Planning & Urban Development Department

February 15, 2018

The Planning and Urban Development Department has reviewed your application for a sign exception to install an additional building sign at 1200 Congress Street for Norway Savings Asset Management Group. The property is located in the B-2 Business Community zone. Per zoning, one sign is allowed per business and the applicant is approved for one sign and requesting an additional façade sign per Section 14- 526 (b)(8)(a)(iv) of the ordinance.

(1) D.F. EXTERNALLY ILLUMINATED PYLON SIGN

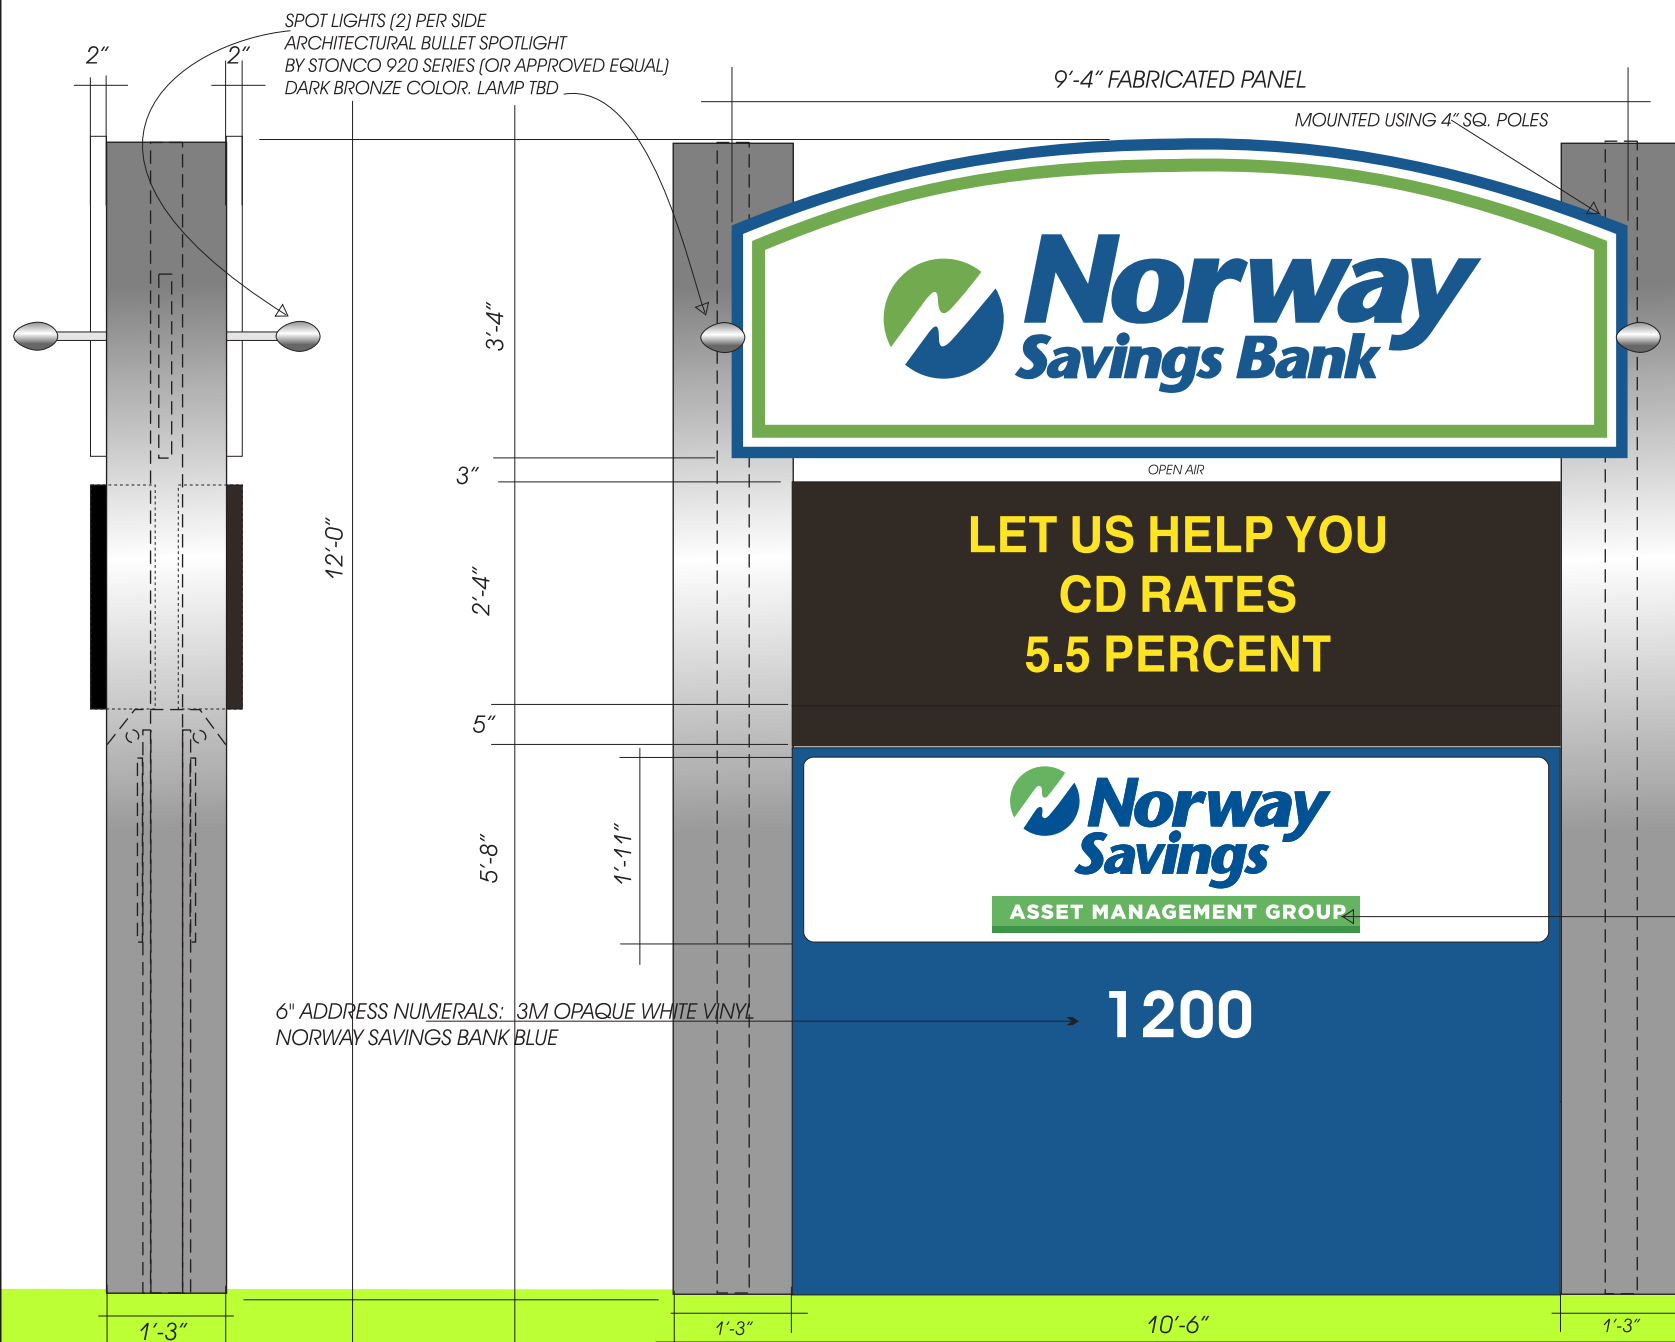
Staff Comment: There are no unique circumstances or characteristics that are associated with the property. Since the asset management is a department of the Bank and the branding is the same, the staff support one building mounted sign rather than one on each side of the building. There is a free-standing sign near the entrance on Congress Street and there is sufficient space on that sign to add the Asset Management sign. The staff supports the use of that free standing for additional signage.

The Planning and Urban Development Department approves the addition of signage on the freestanding sign. The Department denies the request for second building sign, which does not meet the waiver criteria of the site plan ordinance.
